**Statement Regarding Cottam Solar Project- Sturton by Stow Parish Council**

Sturton by Stow Parish Council wishes to register the following observations for Cottam Solar Project. In particular Cottam 1 South.

Our main focus is the draft Consent for Development Order (Rev A).

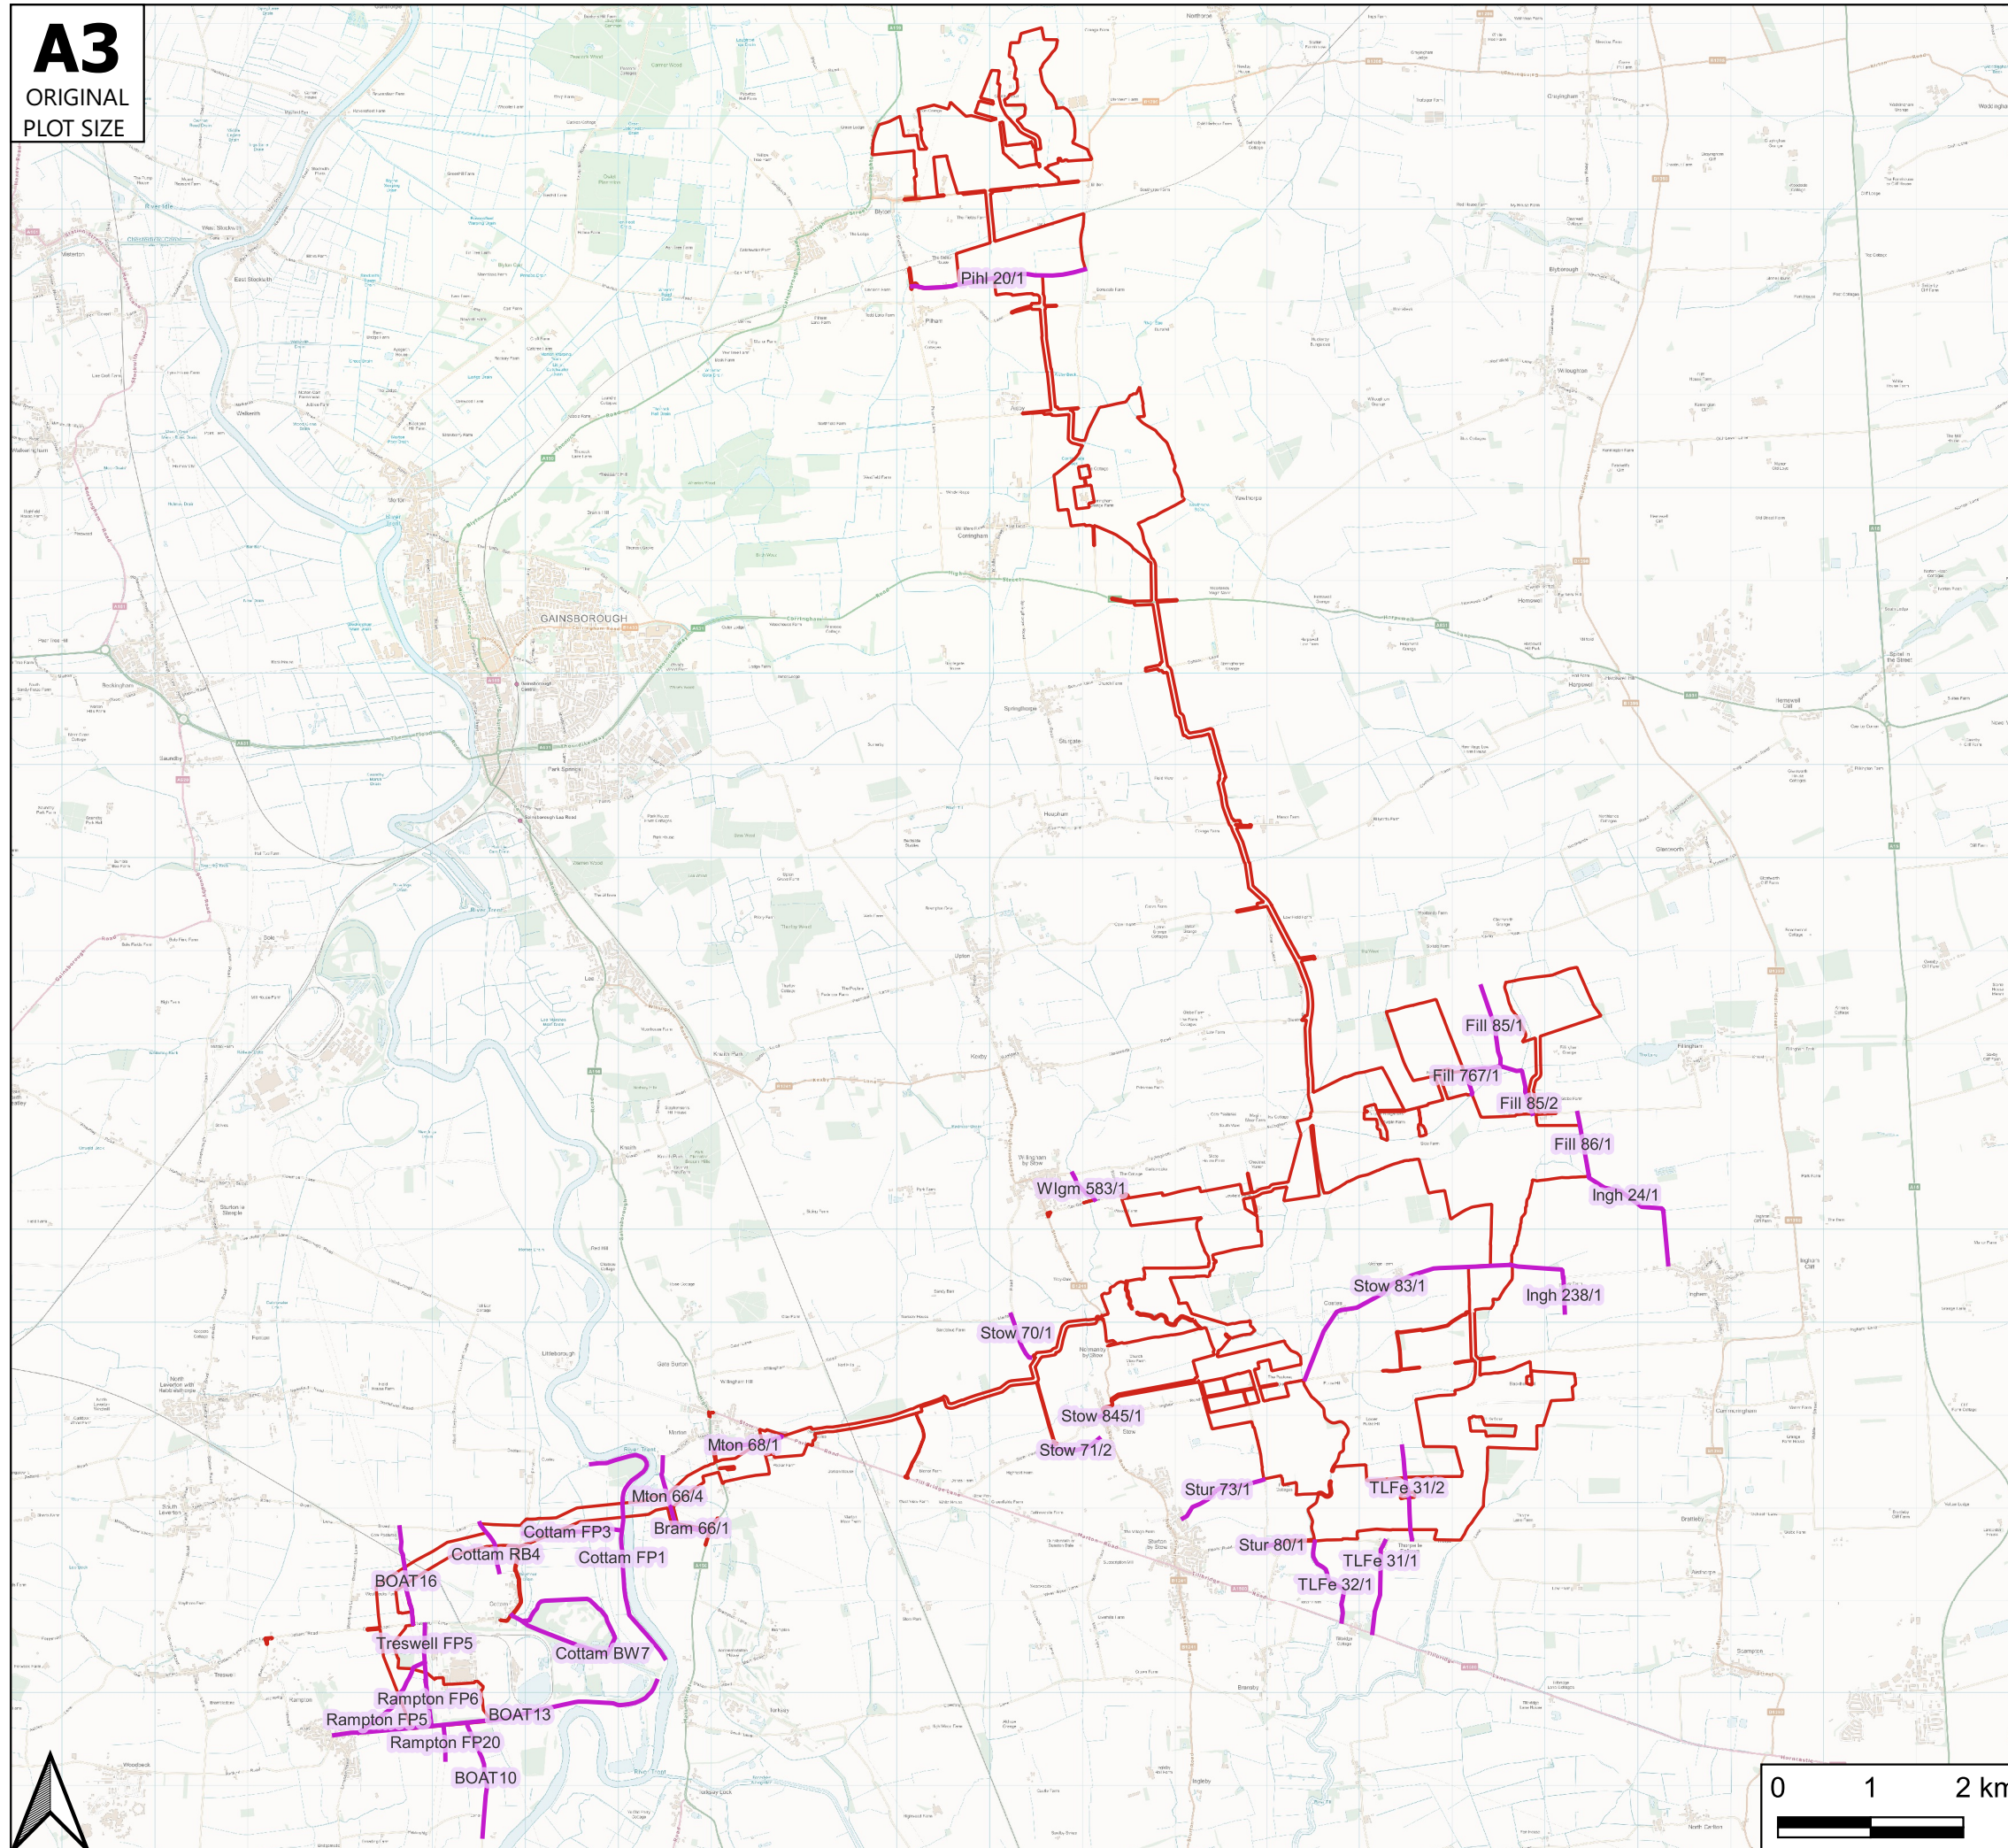
8. The consultation reports make great effort to acknowledge the creation of a permissive path – only one – this is being created to mitigate the closure of a public footpath in Stow. Surely there is much more scope to create walking routes, even if they are permissive for the duration of the project? There is an opportunity to create footpaths, permissive or PROW to add value for residents and visitors alike. Footpath Stur/80/1 will be impacted when Thorpe Lane is closed as per the public rights of way plan **C2.5 Public Rights of Way Plan – see page 14.**
